From: Paton, Julie <Julie.Paton@lancashire.gov.uk>
Sent: 15 September 2023 13:36
To: Planning
Subject: 3/2023/0649 Barn adj Tile Croft Chipping Road Longridge PR3 2NB

Reference 3/2023/0649
Location Barn adj Tile Croft Chipping Road Longridge PR3 2NB
Proposal We've got an application to convert an agricultural building into two dwellings

DRAWING TITLE  
Existing & Proposed Site Plans

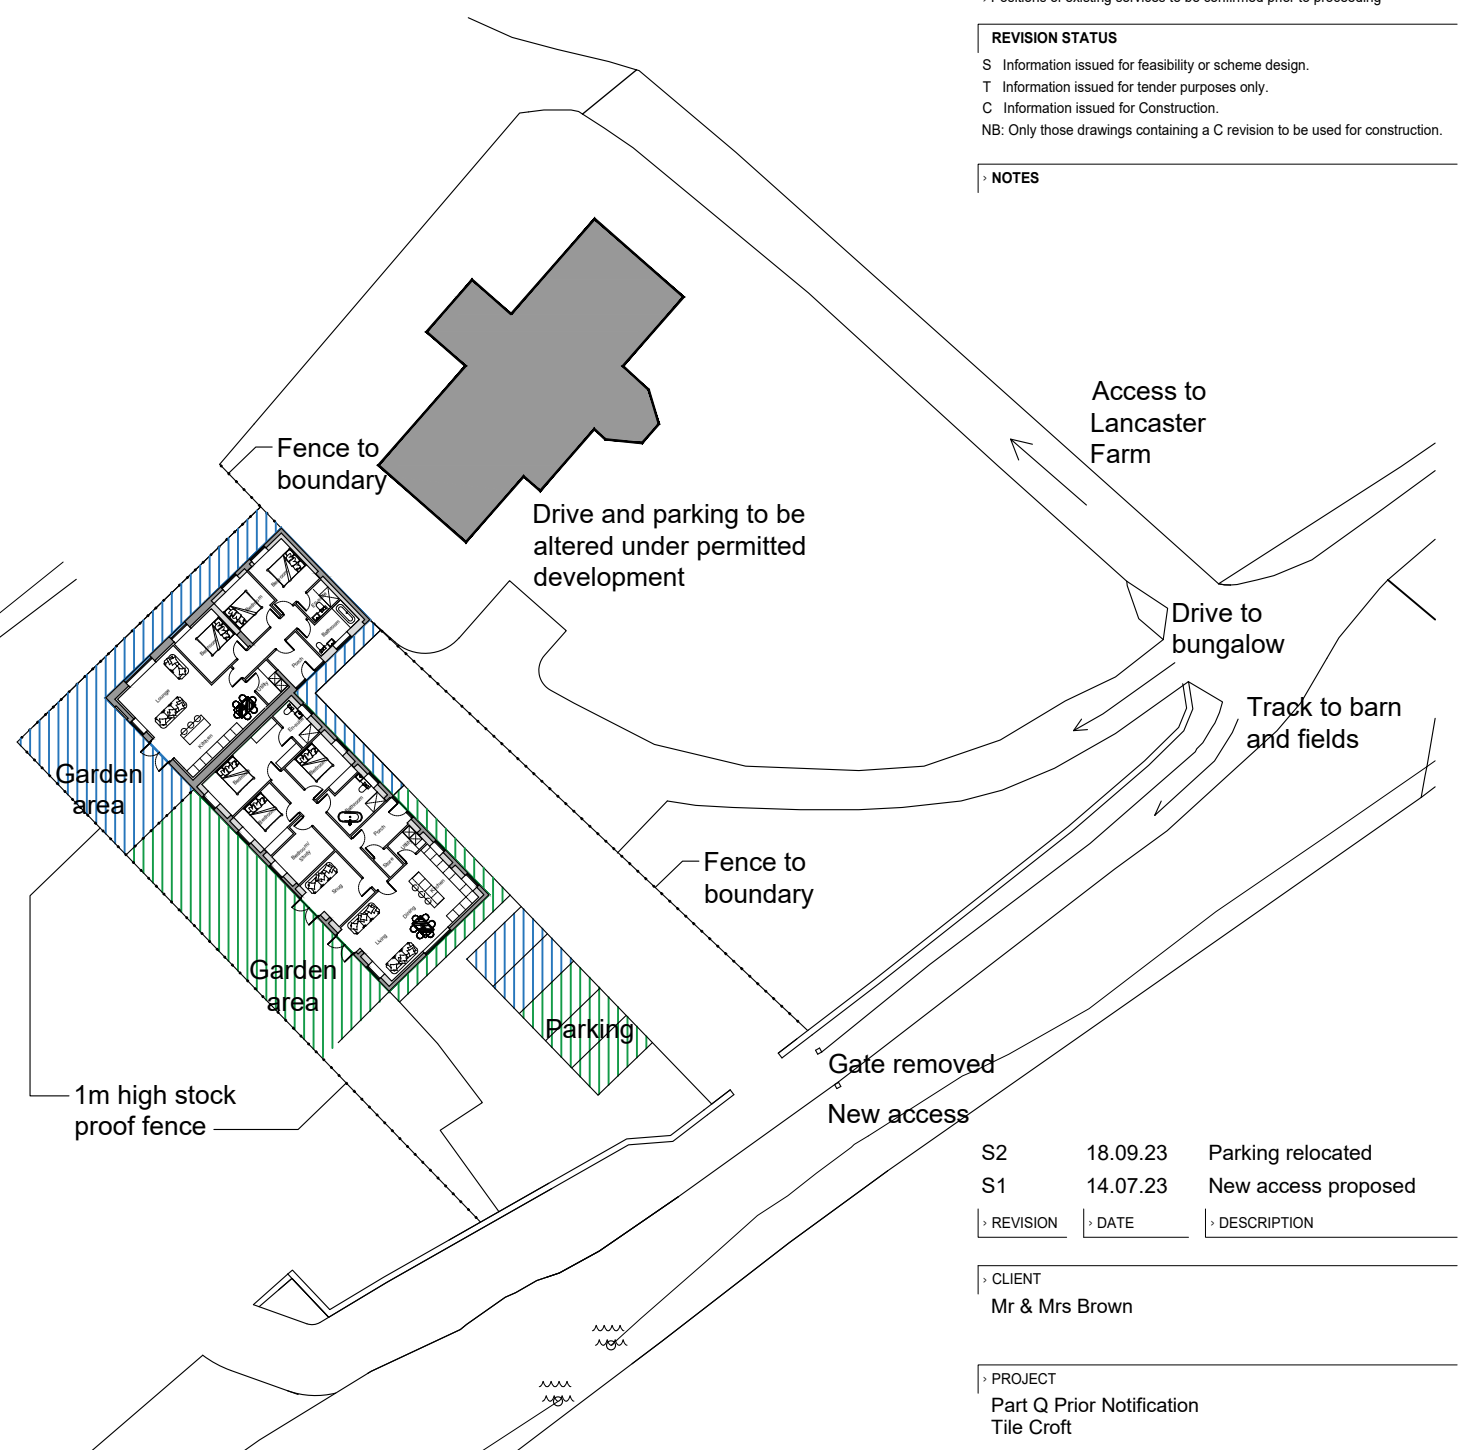
The proposed parking area will obstruct footpath FP0341068, as shown on the attached overlay, triggering a Diversion Order under the provisions of the Town and Country Planning Act 1990 Section 257 (TCPA90 S257). TCPA90 S257 orders are administered by the authority that is considering, or has granted the planning permission, in this instance Ribble Valley Borough Council.

DRAWING TITLE
Existing & Proposed Site Plans

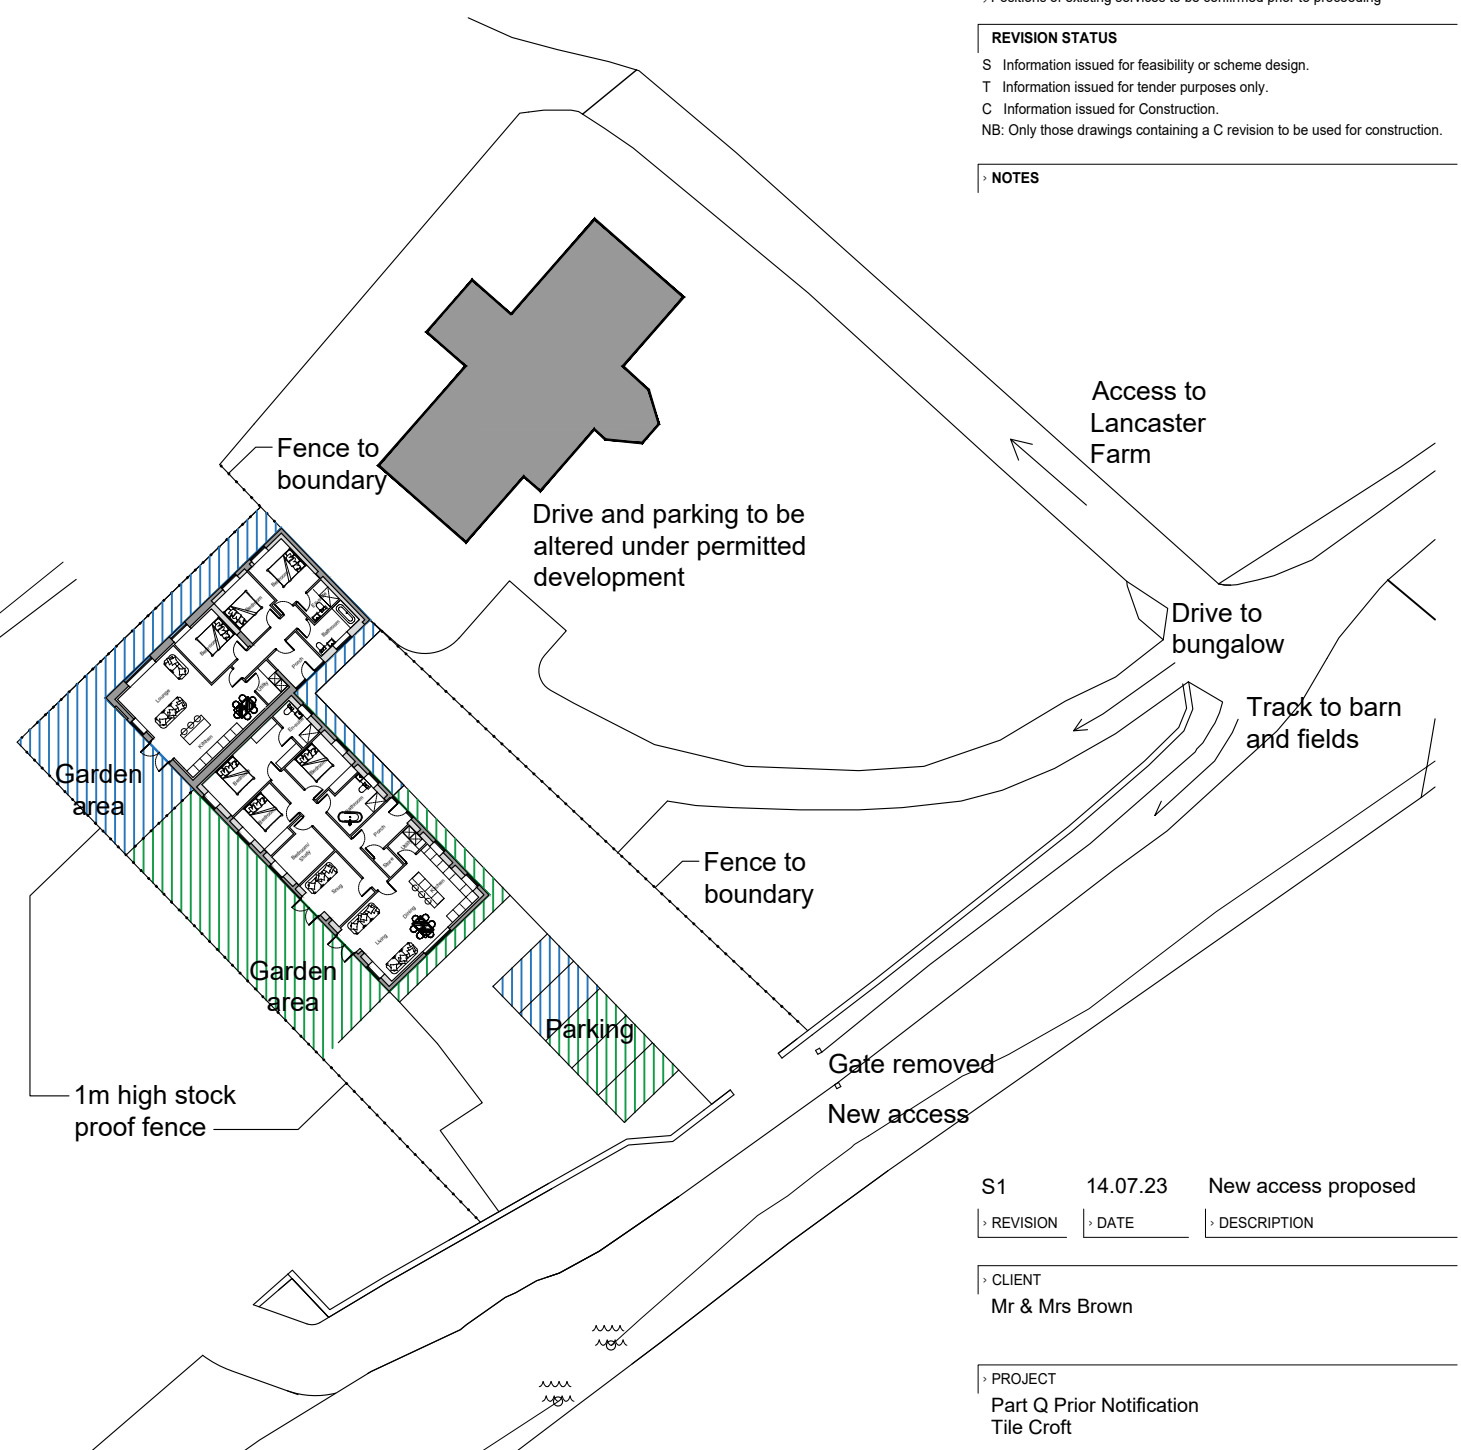
The detail of the exact alignment of the new route, the construction specification and any association works would need to be agreed with public rights of way before the necessary TCPA90 S257 Order is made. I can advise that the new route must have a minimum width of 2 metres, have a firm properly constructed surface with no gates or stiles crossing the new route.
